## THE BRITISH HORSE SOCIETY – BEDFORDSHIRE

### Written Submission for Deadline 1

This submission provides further information on matters raised in RR-1253.

Figure 2-5 Indicative Construction Access and Compounds (Rev P01)

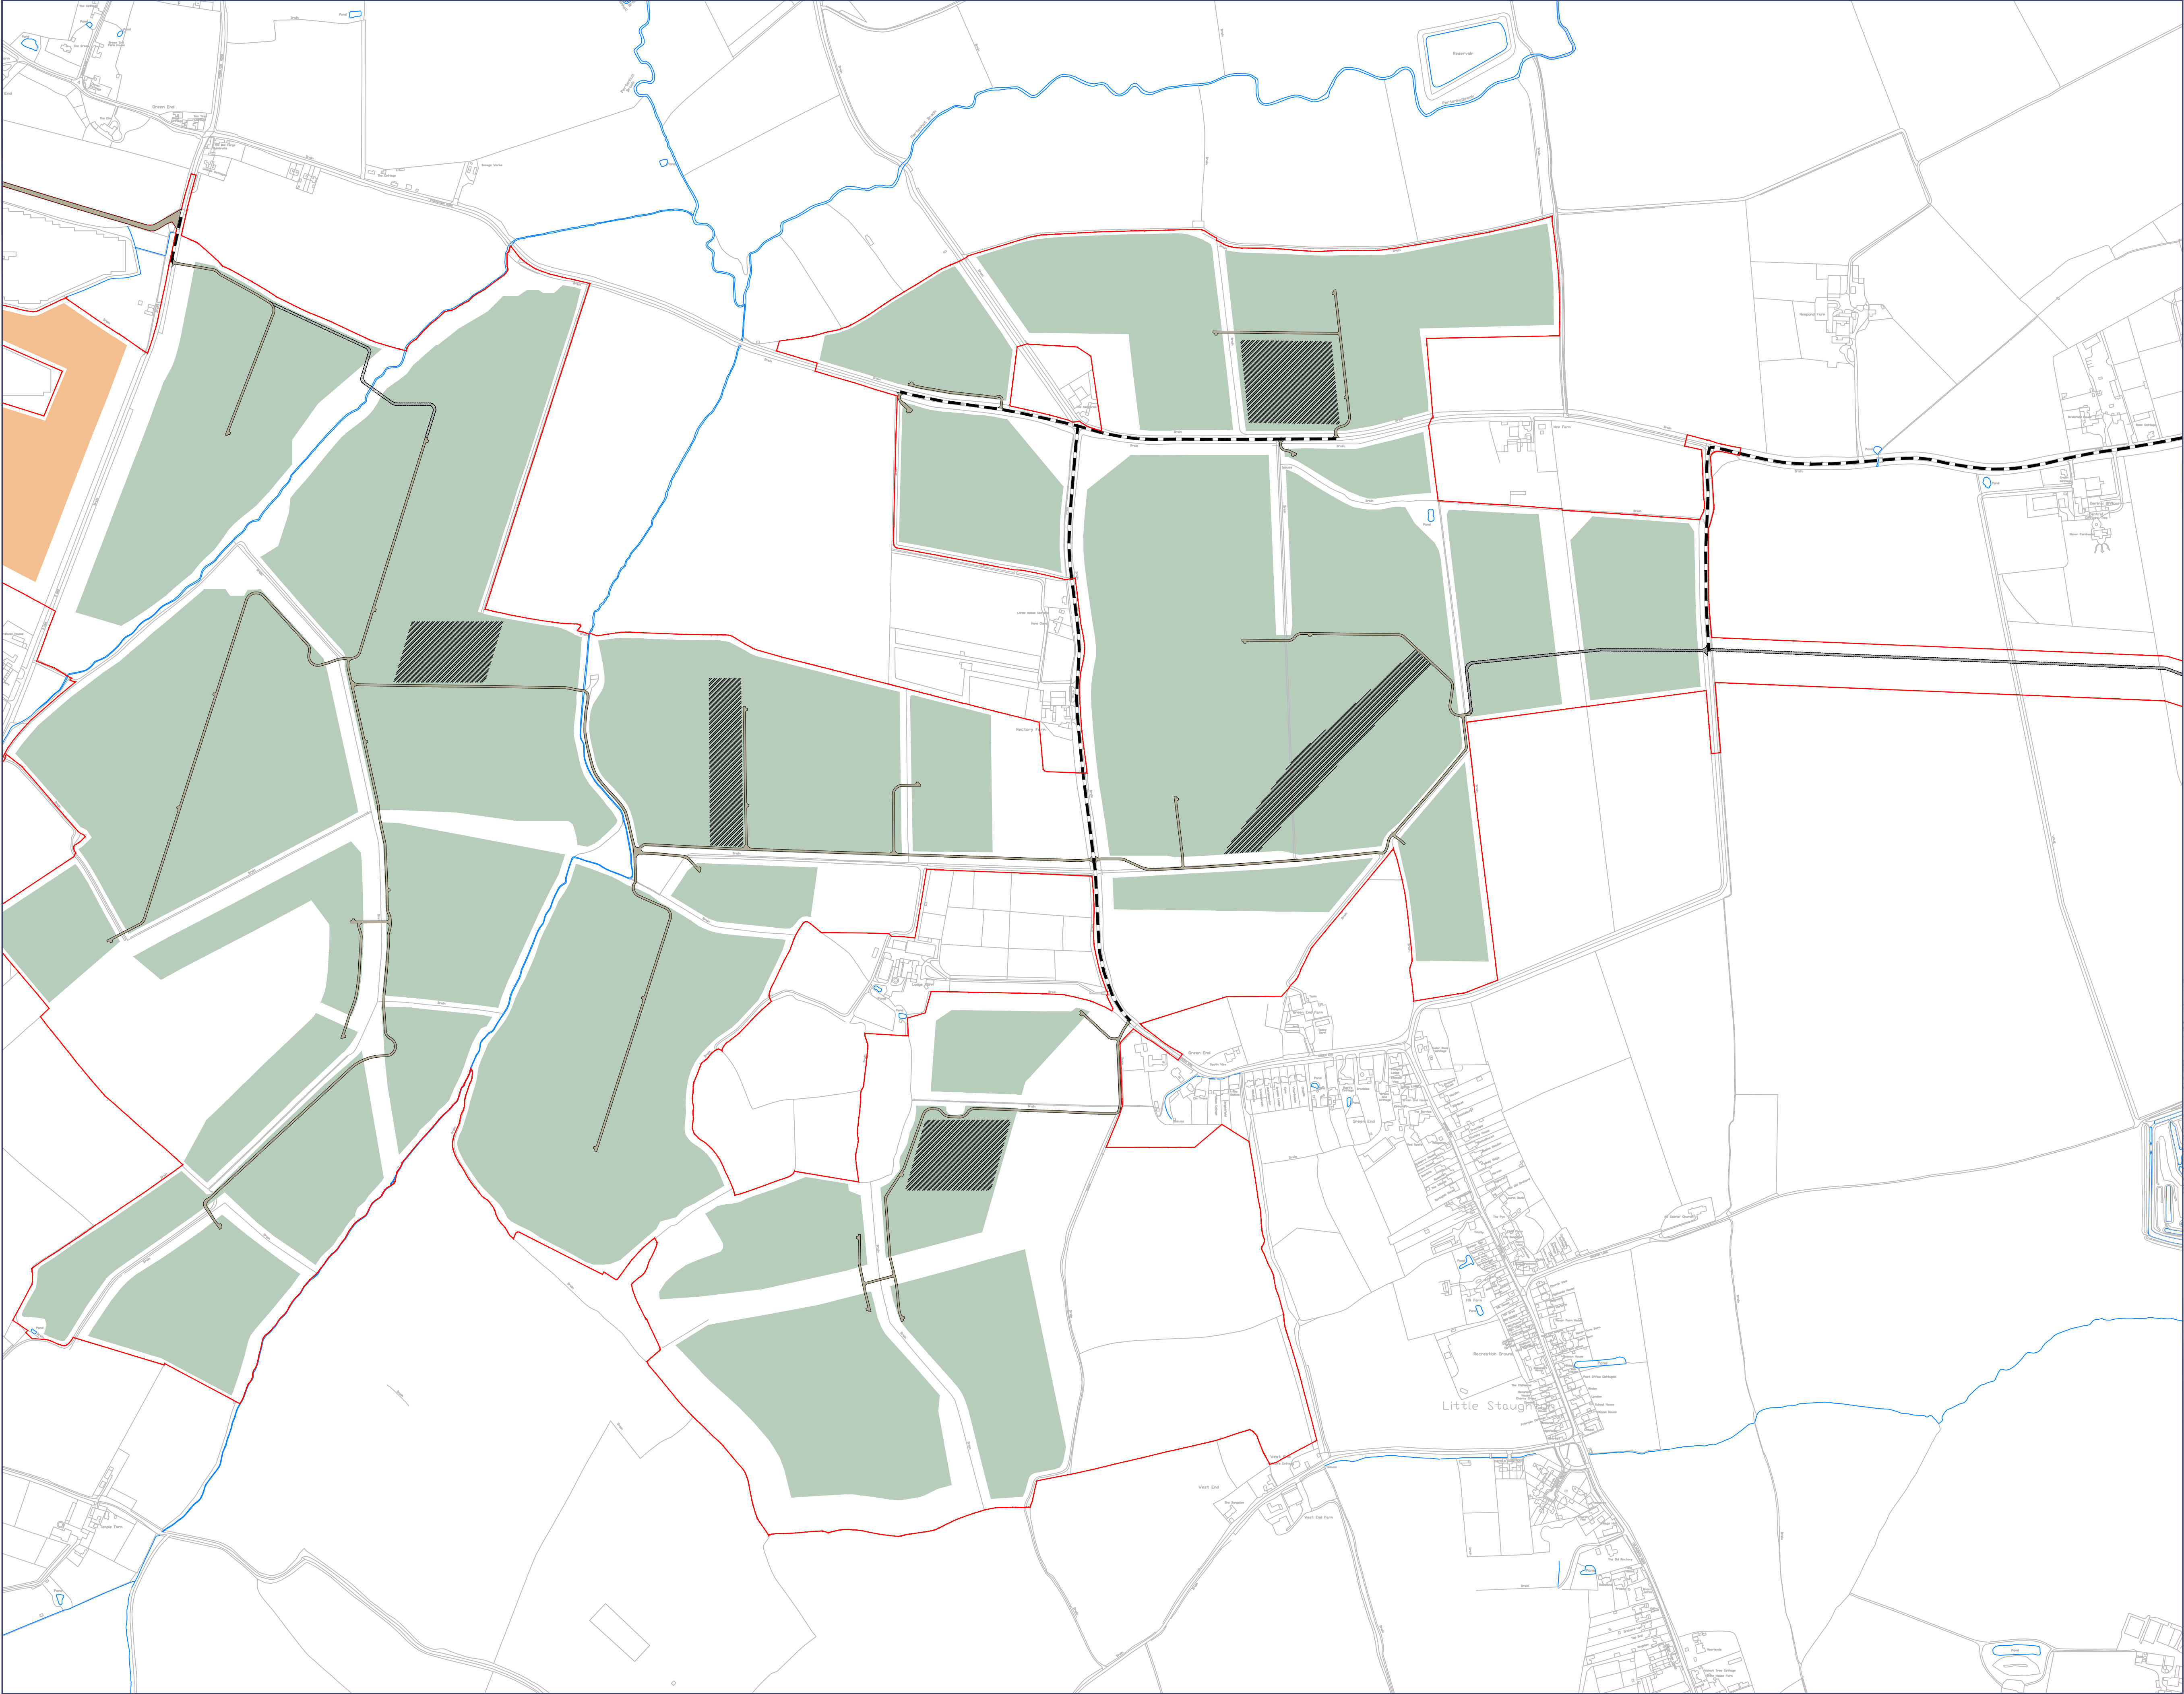
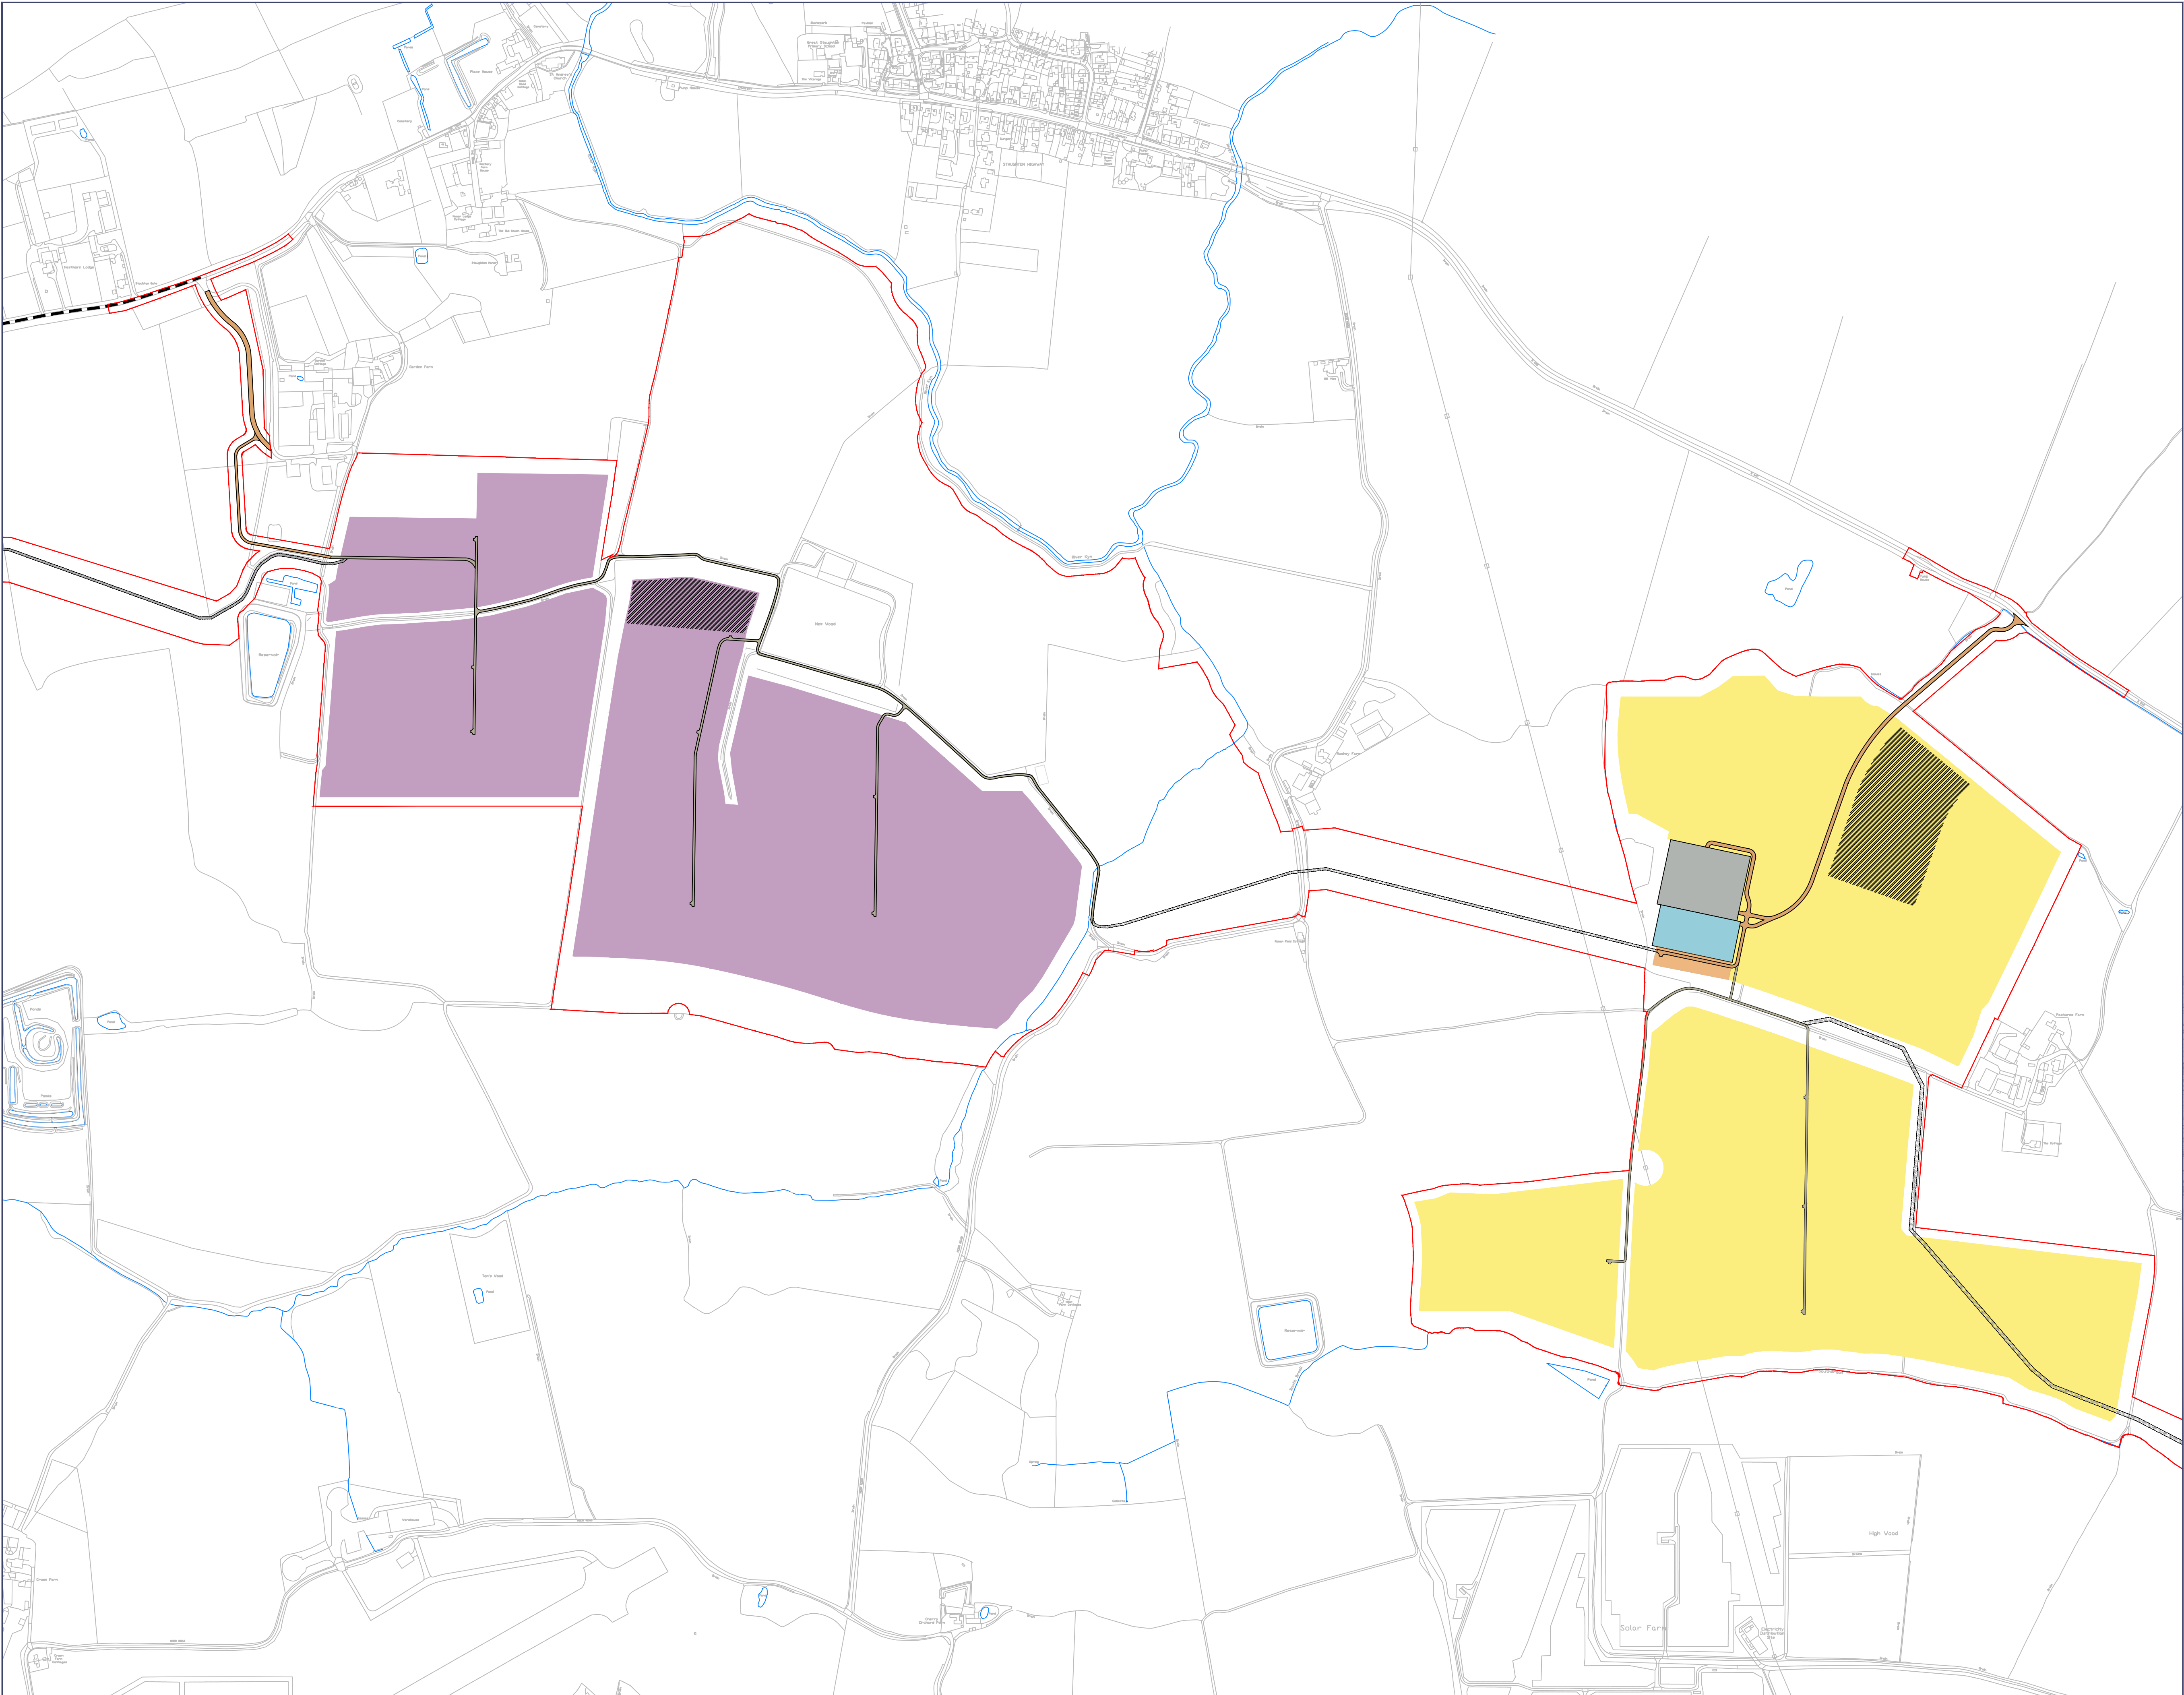
Each of the country roads around Sites A and B is used by equestrians (and also by cyclists). There appears to be no effort made to minimise the use of these roads. There are three sections of road that are planned to be used by construction traffic, each roughly 1km, and in each case there is scope for an alternative safer option available within the development site:

1. All traffic between Sites C and B (so all deliveries etc for both Sites A and B – nearly 2,400 loads or 4,800 trips) will be directed via the narrow Great Staughton Road rather than on an internal access track along the line of or alongside the cable corridor between Site C and B.
2. Access to the southern and northern sections of Site B will use Green End Road – the volume of traffic is not easy to estimate but alternative internal tracks could be provided, requiring only a crossing of Green End.
3. Access to the very northern sections of Site B – those to the north of Great Staughton Road around Kangaroo – will use that road from the junction with Green End Road. Once again, internal routes could be used with just crossings of the road.

APP-125 shows the current proposed routes as black dotted lines in Figures 2-5c and 2-5d.

In summary, these three sections of road do not need to be used for construction traffic access as alternatives could be provided within the site – with just three road crossings required. For regular maintenance vehicles during operation, it would be acceptable for the lower number of smaller vehicles involved to use the local roads. But for any major repowering or replacement during the lifetime of the site and for decommissioning, internal routes should again be used, which might well involve some detailed planning but should be achievable.
